WEST SUSSEX COUNTY COUNCIL CONSULTATION

TO:	Arun District Council FAO: Anita Gardner	
FROM:	Highways, WSCC	
DATE:	24/10/2018	
LOCATION:	4, Sea Lane, Ferring, Worthing, BN12 5DS	
SUBJECT:	FG/168/18/PL Erection of 2 bedroom single storey dwelling to rear of existing property.	
DATE OF SITE VISIT:	N/A	
RECOMMENDATION:	☒ Advice ☐ Objection ☐ Modification ☐ No Objection ☐ More Information ☐ Refusal	
S106 CONTRIBUTION TOTAL:	£N/A

Proposed Site Layout

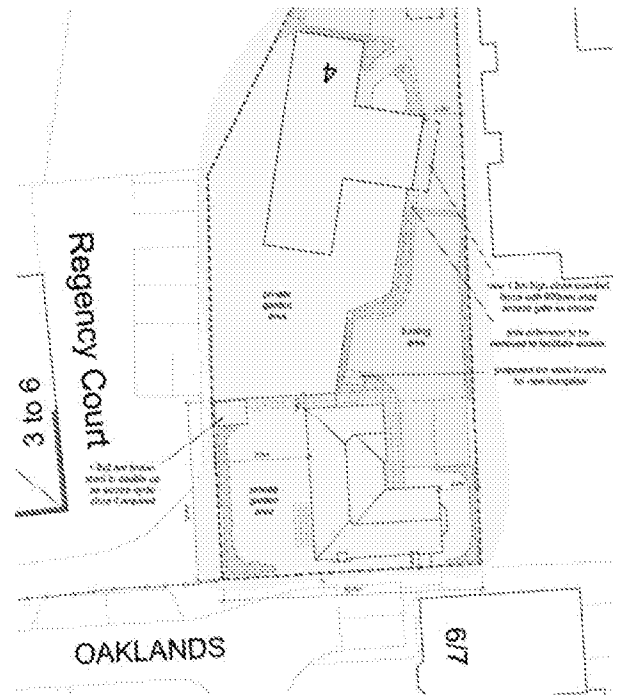
The proposal will result in the removal of the existing garage and side extension to 4 Sea Lane. The access drive to serve the proposed dwelling will be 2.8m at the narrowest point. Whilst not strictly a matter for the Highway Authority, the applicant should be aware that access for fire appliances may need to be demonstrated in order to meet building regulations.

The proposed plans demonstrate that two parking spaces will be provided per dwelling. This is anticipated to provide sufficient parking for the development. The proposed spaces meet the minimum specifications of 2.4 x 4.8m as set out in Manual for Streets (MfS). A turn on site is provided for both dwellings, enabling vehicles to exit onto the publically maintained highway in a forward gear.

No part of the development shall be first occupied until the vehicle parking and turning spaces have been constructed in accordance with the approved plan. These spaces shall thereafter be retained for their designated use.
